Ribble Valley Borough Council
By email

Your ref: 3/2021/0275
Our ref: DC/21/1403v8
Date: 02-FEB-23

Location: Land behind the Dog Inn Market Place Longridge PR3 3RR
Proposal: Proposed erection of 9 new dwellings and associated works

OBJECTION AND REQUEST FOR FURTHER INFORMATION

Site Section through The Dog Inn, Plot 2 and 36 Darwen Close

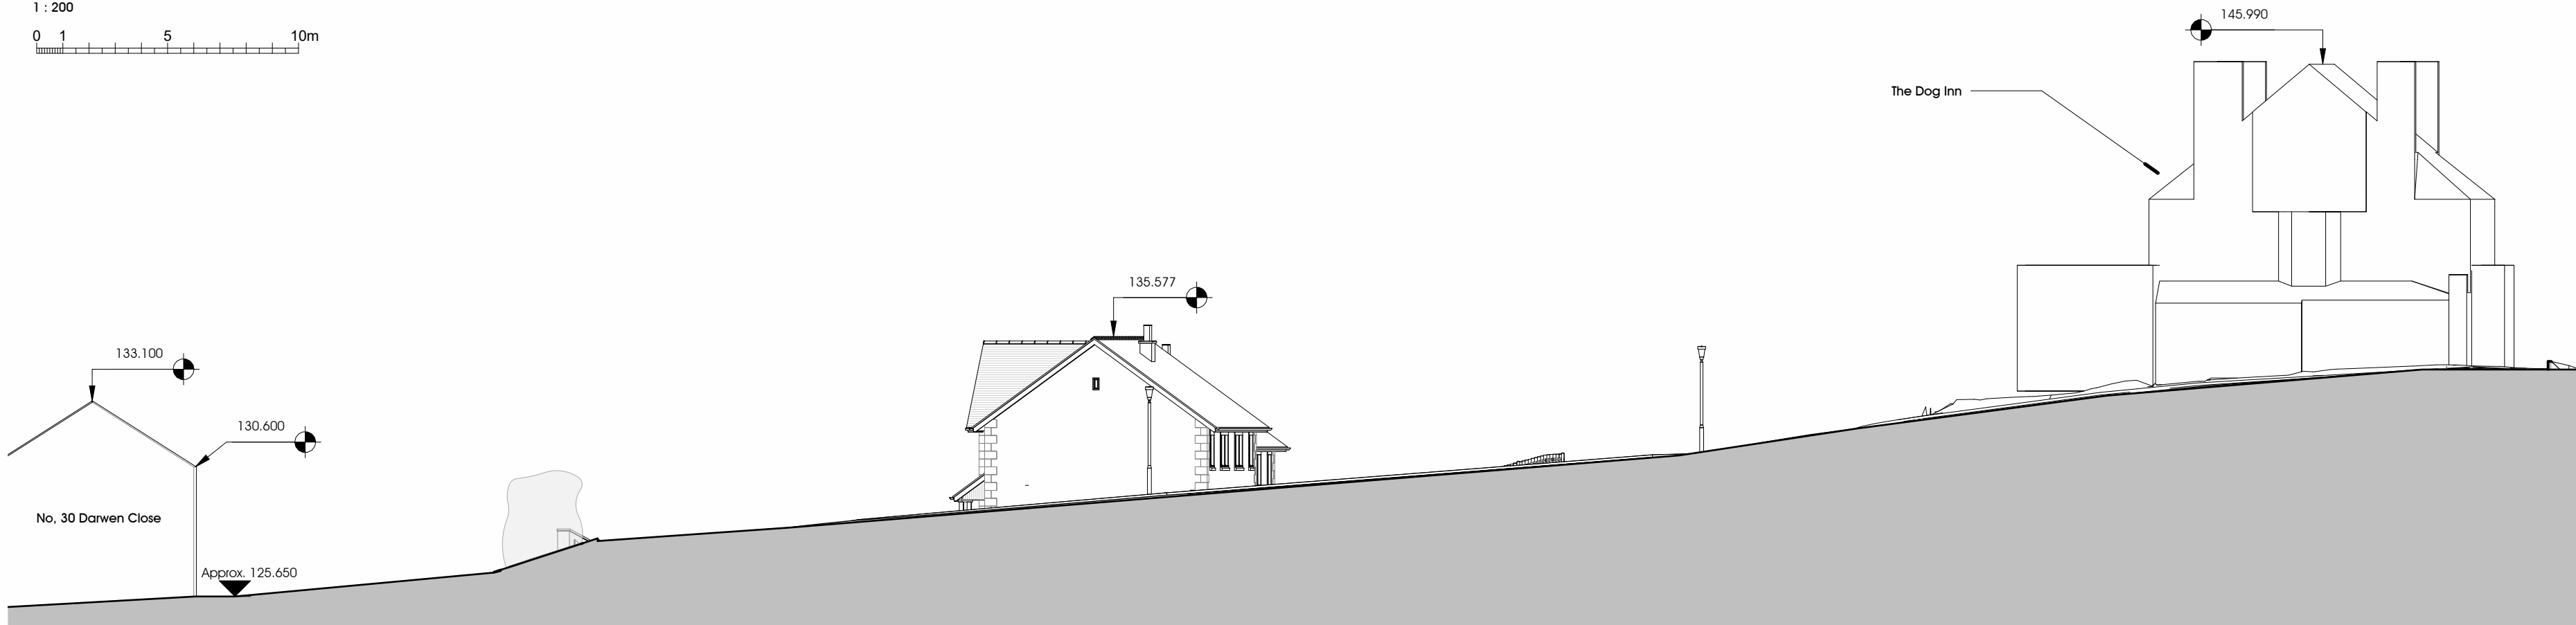
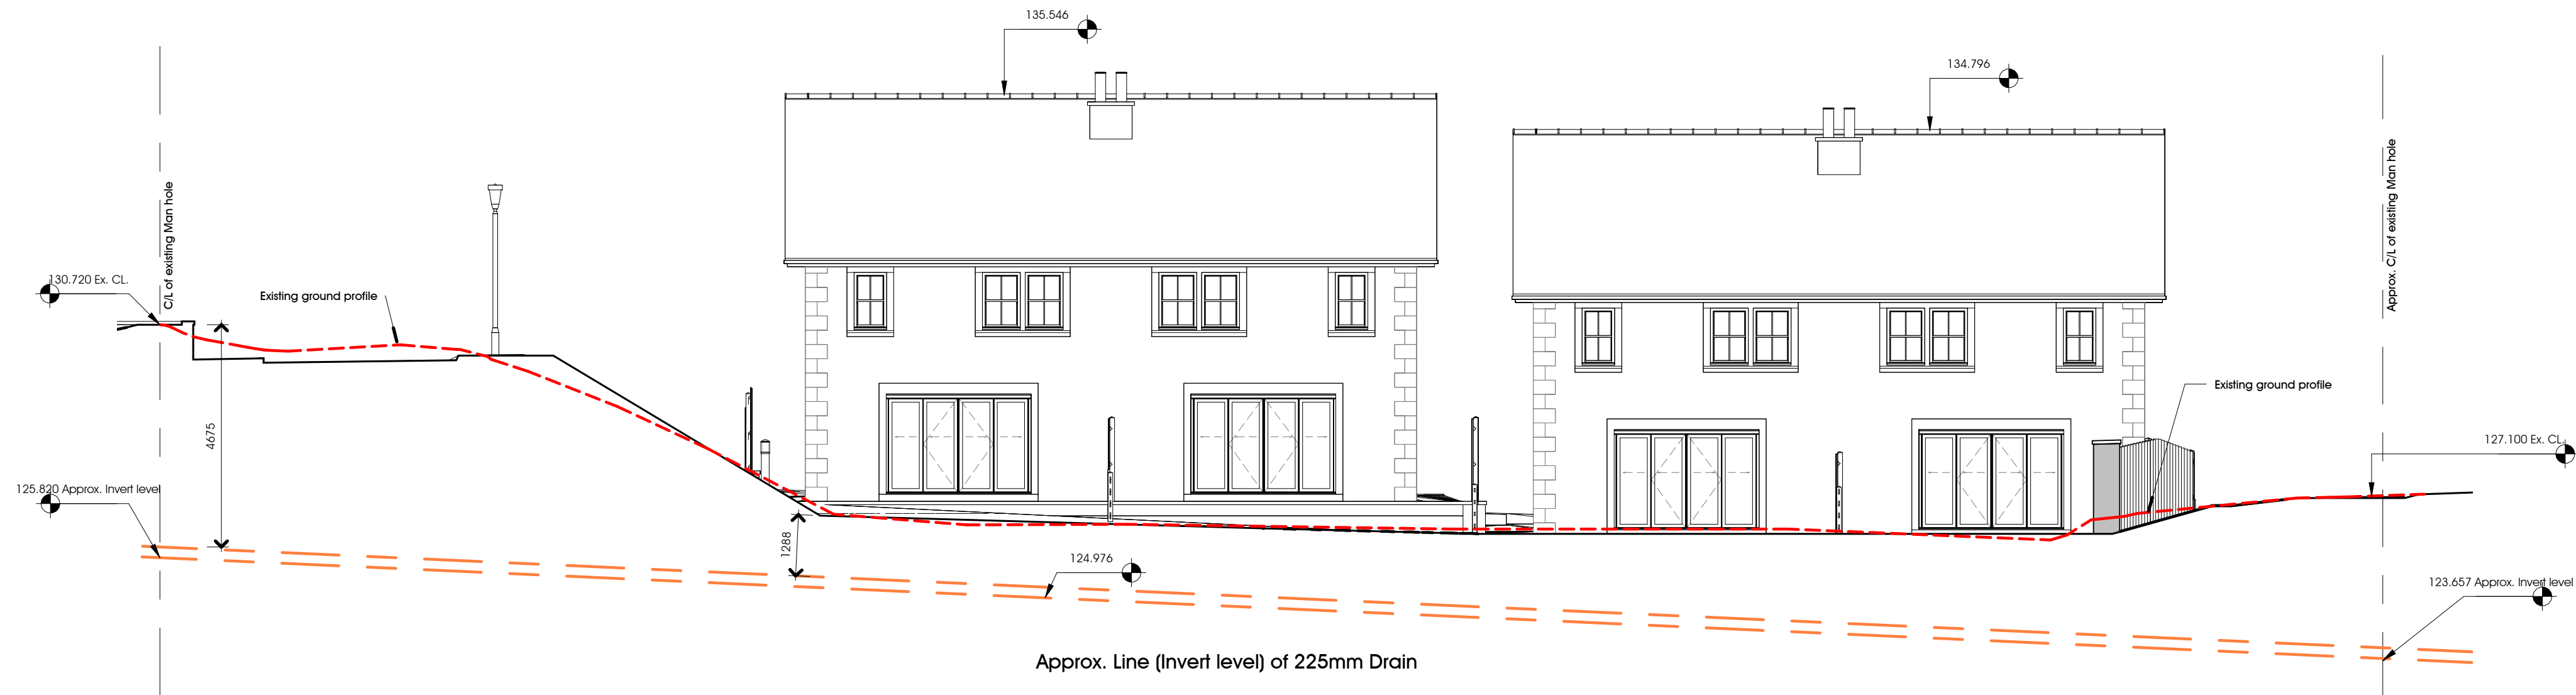
Whilst the above matters have been addressed we still have serious concerns regarding the potential overland flow from sewer surcharge and the potential flood risk to the proposed properties which are at lower level than the surrounding sewer manhole cover levels.

We request that the applicant provides further information on the proposed measures to mitigate against potential property level flooding. These measures should include raising property finished floor levels and providing physical mitigation features. It is requested the applicant discusses these matters directly with United Utilities at wastewaterdeveloperservices@uuplc.co.uk

It is requested that an overland flow exceedance plan is submitted which should consider and show that potential overland flow from sewer surcharge is directed away from the properties. It is important that the final topography of the site guides the flows from any surcharged manhole away from the proposed dwellings and their associated curtilages.

Section along existing drain

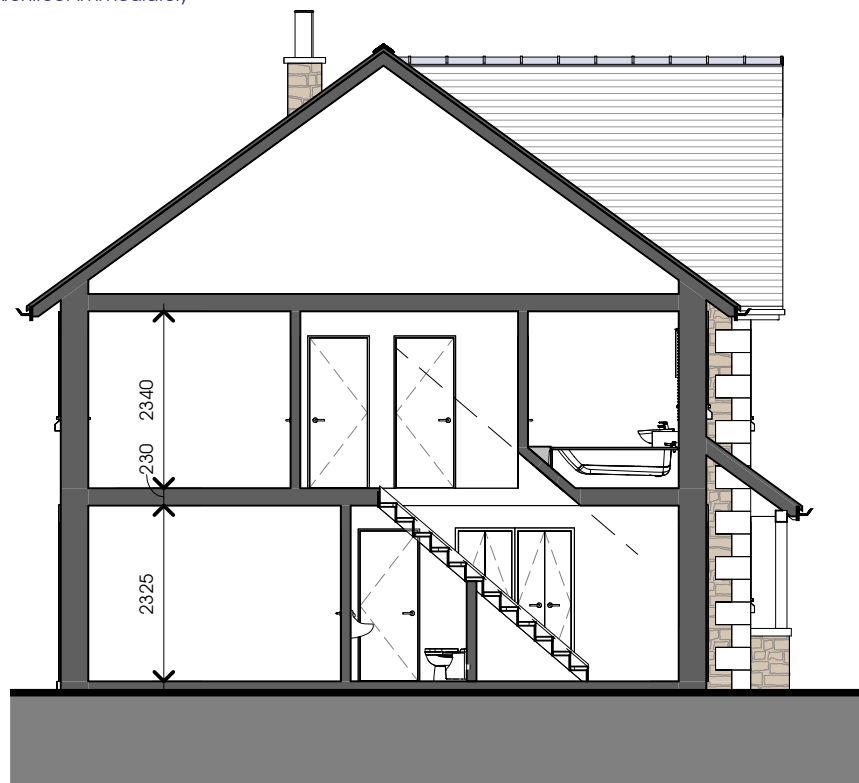
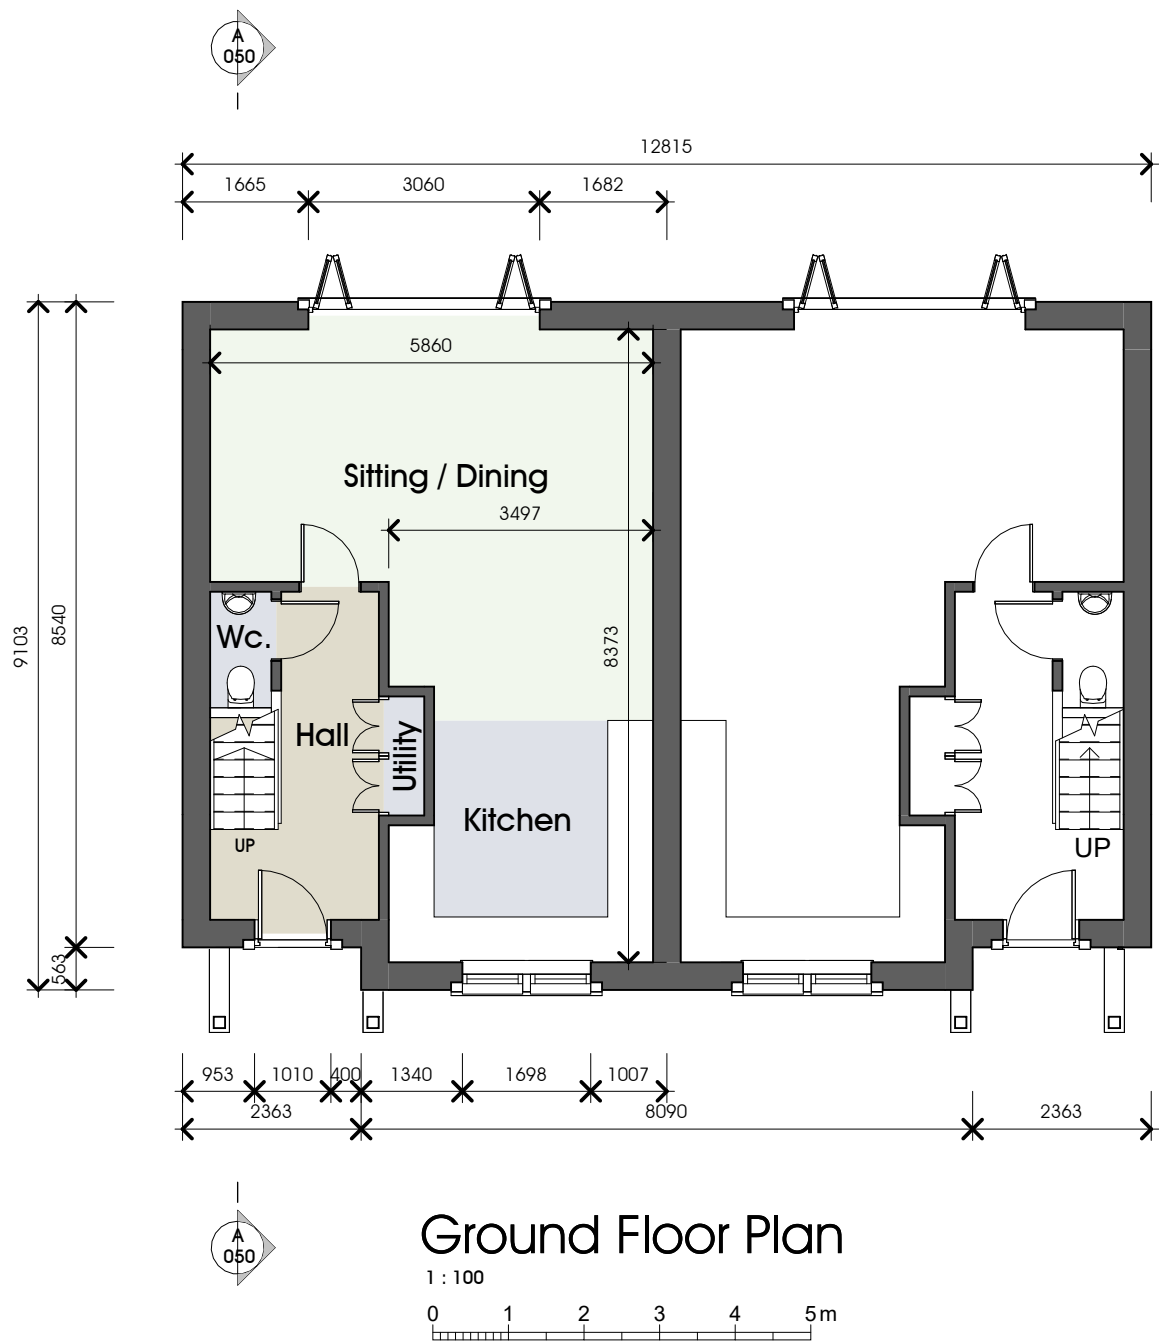
We request that the applicant provides further information to confirm whether the existing public foul water sewer running through the site has been surveyed in its entirety to establish its accurate location especially as the proposed dwellings are located close by. It is requested the sewer is accurately located.

We request that the applicant confirms whether there are proposed changes to ground levels over or near to the existing public sewer.

We request that further information is provided regarding the location and details of any proposed retaining walls which are proposed over or near to the public sewer located within the site.
